Your Ref: OWPC15521
Our Ref: R/184/17/PD 08-08-2017
Please ask for:
Mrs A Gardner

Notification for prior approval under class C for a change of use from a shop (Class A1)
to a restaurant/cafe (Class A3)

51 Sea Lane Rustington

**APPENDIX ONE:
DRAWING SHOWING EXTERNAL EXTRACT AND VENTILATION EQUIPMENT PROPOSED**

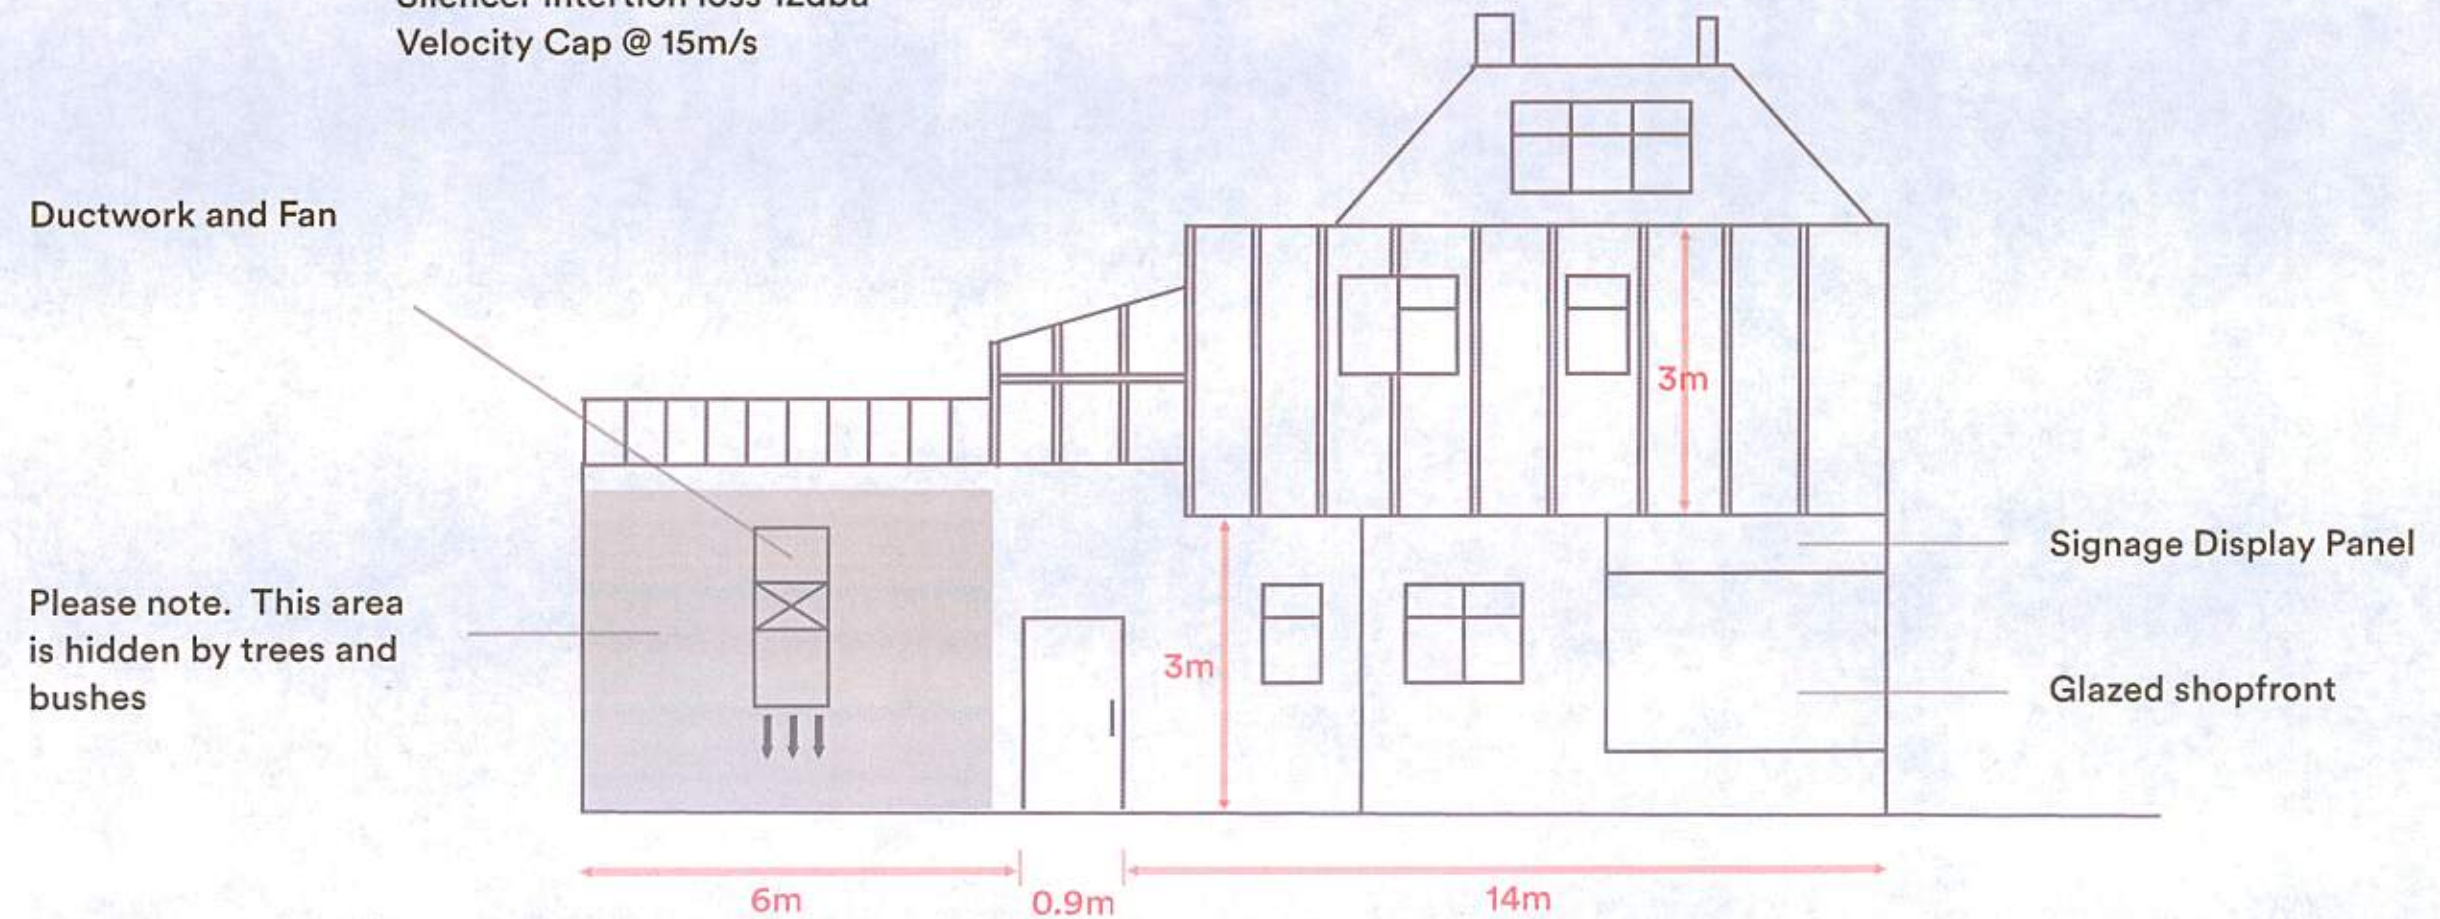
5. Having the proposed extractor fan blowing food smells into my road, will change the nature of that end of the road, and spoil my enjoyment of my property. My house is almost exactly downwind from the direction of the prevailing wind, so this smell would be very pervasive and constant.

7. I really wonder whether the proposer has considered the potential danger of a faulty extractor fan shooting sparks, pointing straight at the thatched cottage roof just a few yards away. Surely this can't be allowed. Surely not.

APPENDIX TWO:
DRAWING SHOWING PROPOSED REFUSE FACILITIES

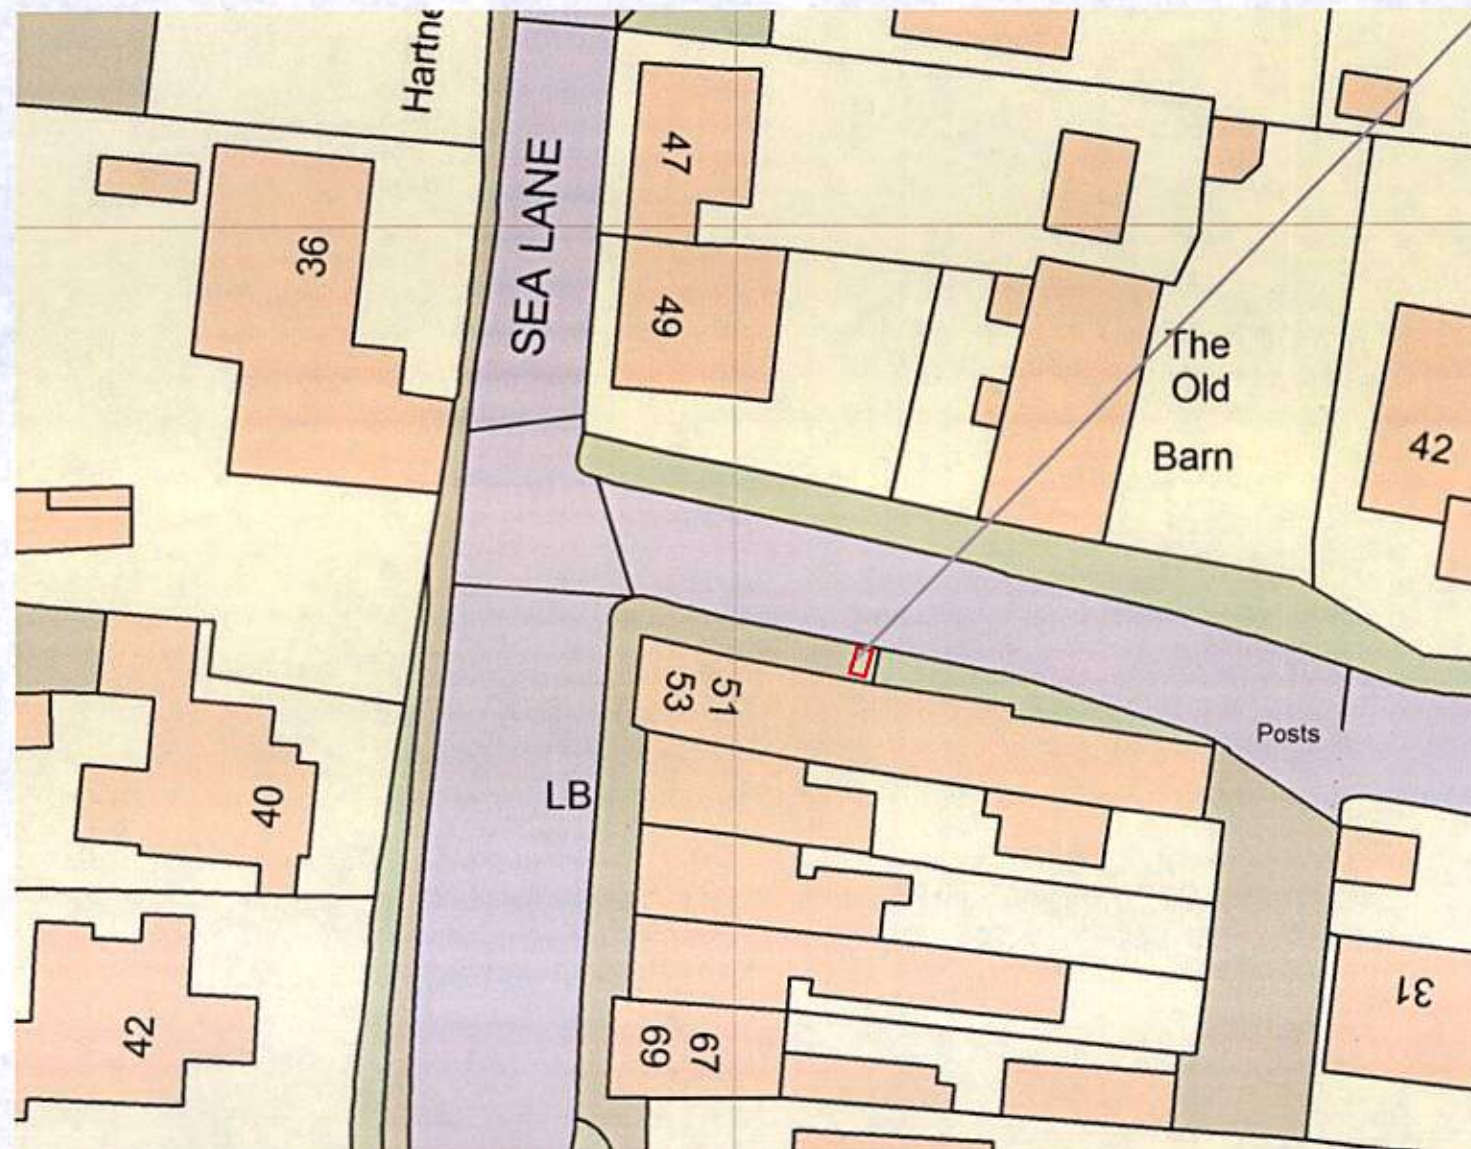
4. Bags of food waste, awaiting rubbish collection (see 3 above) will likely be torn open by gulls and foxes, and be unsightly and a possible health hazard.
